Re: 6 The Dales, Langho, Blackburn BB6 8BW
Planning Application No: 3/2024/0183

We are writing to object to the amended plans of 29 April.

Proposed new fence at :	
6 The Dales Langho BB6 8BW	
CLIENT:	Mr & Mrs Marcinkiewicz
DATE:	February 2024
SCALE:	1:100 @ A1
DWG No:	Elevations & Layouts
L.A:	
AMENDMENTS:	DATE:
ENTWISTLE DESIGN SERVICES	
7 Edgefield Astley Village Chorley PR7 1XH	
Tel:01257 274976	
E-Mail entwistledesign@aol.com

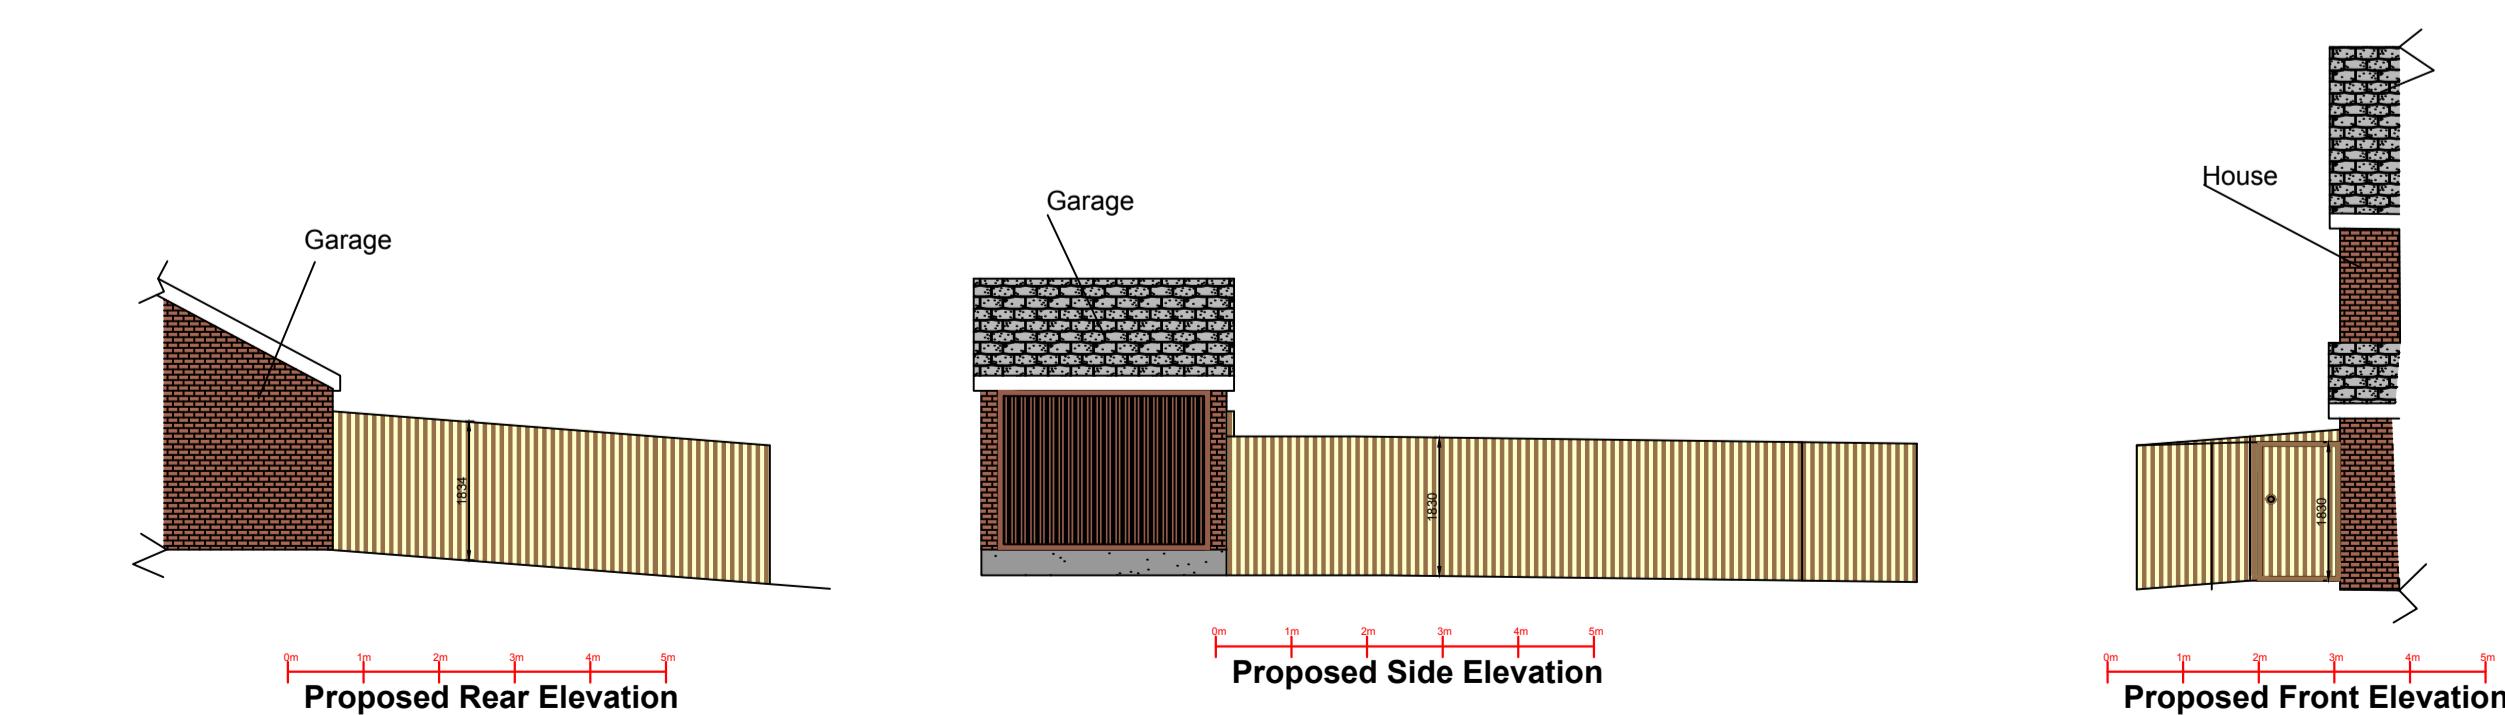
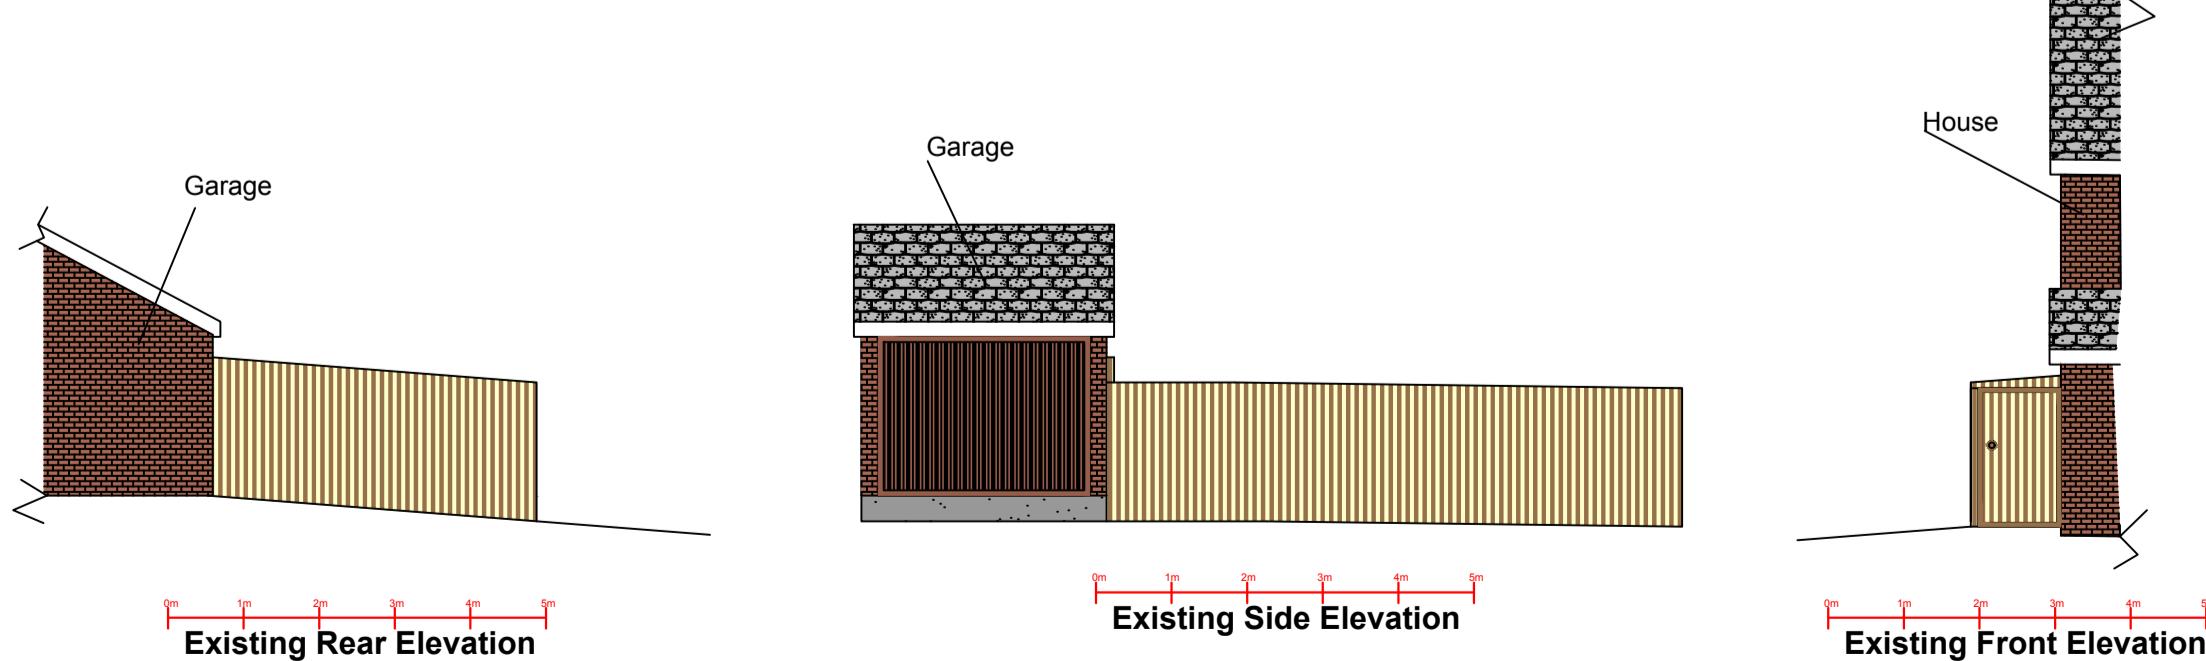
It is not clear from the plans what length the new fence will be.

The plans appear to show the fence terminating at distance (A) from the front of the property, the same as the existing fence. But there is statement on the far right of the drawing saying the new fence will be 1.5m longer.

Similarly, fence (B) is shown extending up to the edge of the service strip, a distance of approximately 1.2m; but the statement on the drawing refers to a 1.5m increase, which won't be feasible due to the location of the service strip.

The revised plans do not show the x3 trees on the fence line, which the applicant wants to remove. The trees are referred to in the planning application, but are not shown on the drawings ... why not?

The boundary lines shown on the new drawings are incorrect as they don't allow for the 2m Service Strip, see Fig 6. The correct boundary lines are shown below in red.
